Application for Planning Permission for Works or Extension to a Dwelling

Development Rebuild garage and rear extension
Location Bilsham House Bilsham Road Yapton Arundel

Existing Rear Elevation

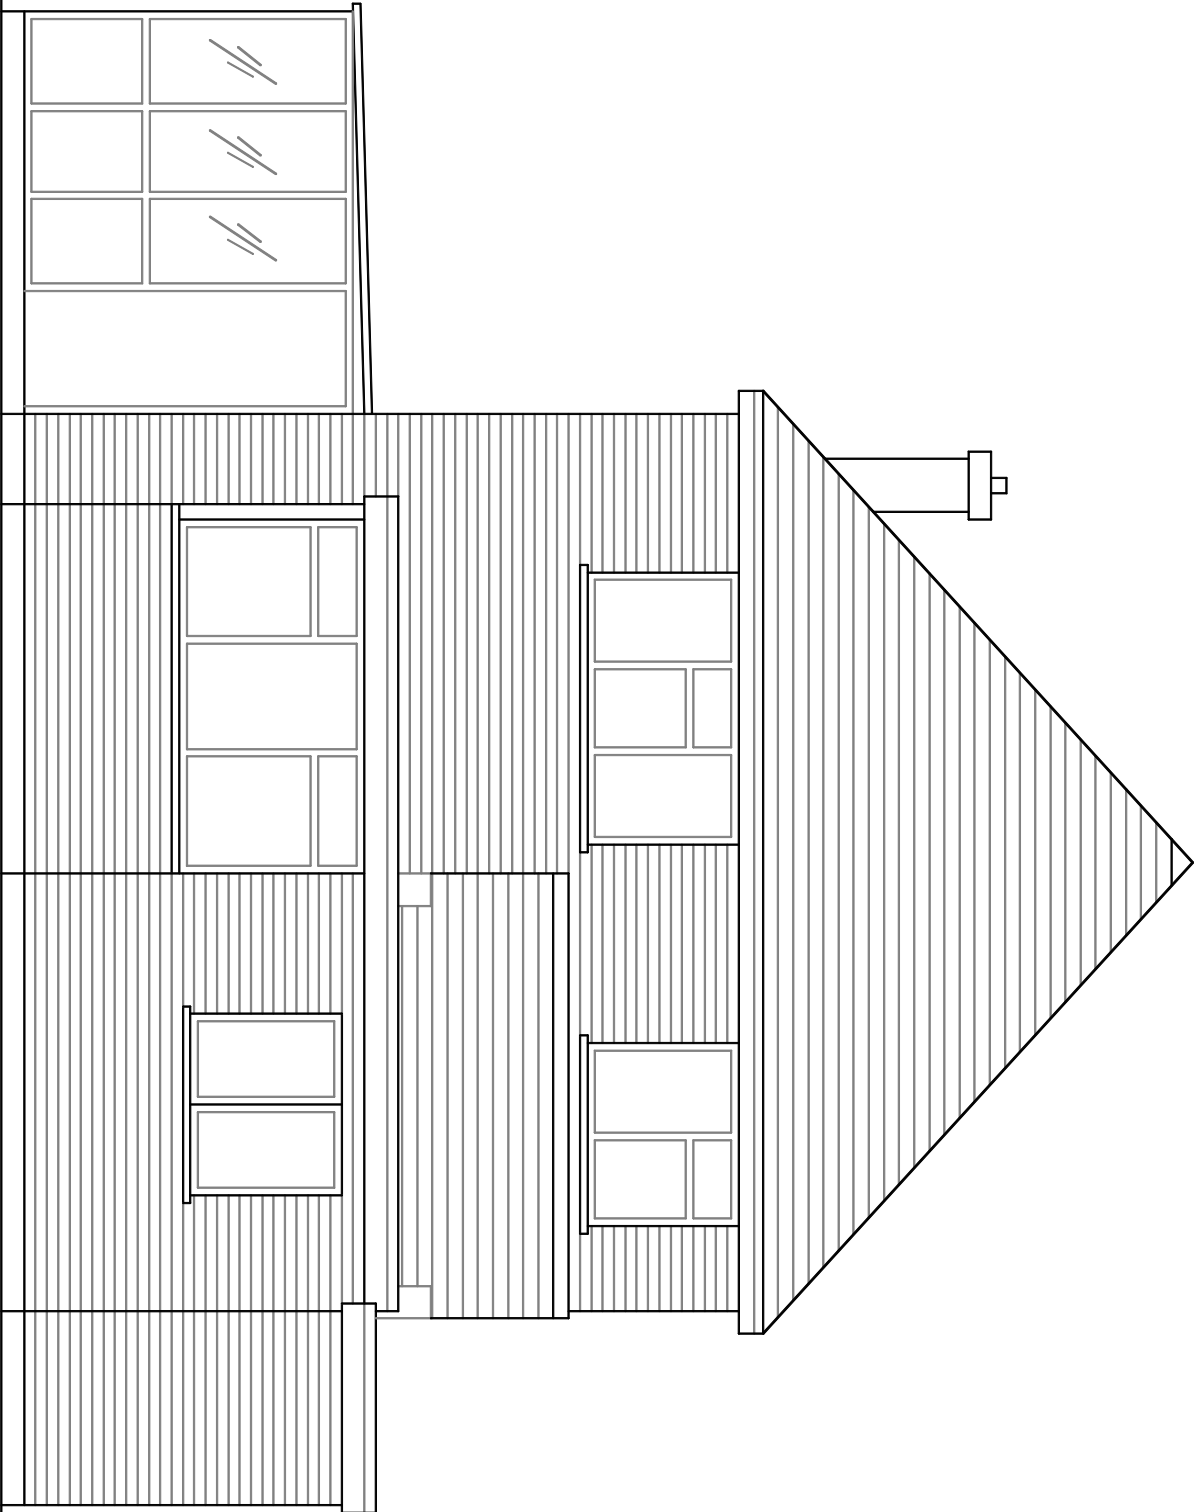
The existing rear elevation does not accord with the existing rear floor plan. Please amend accordingly.
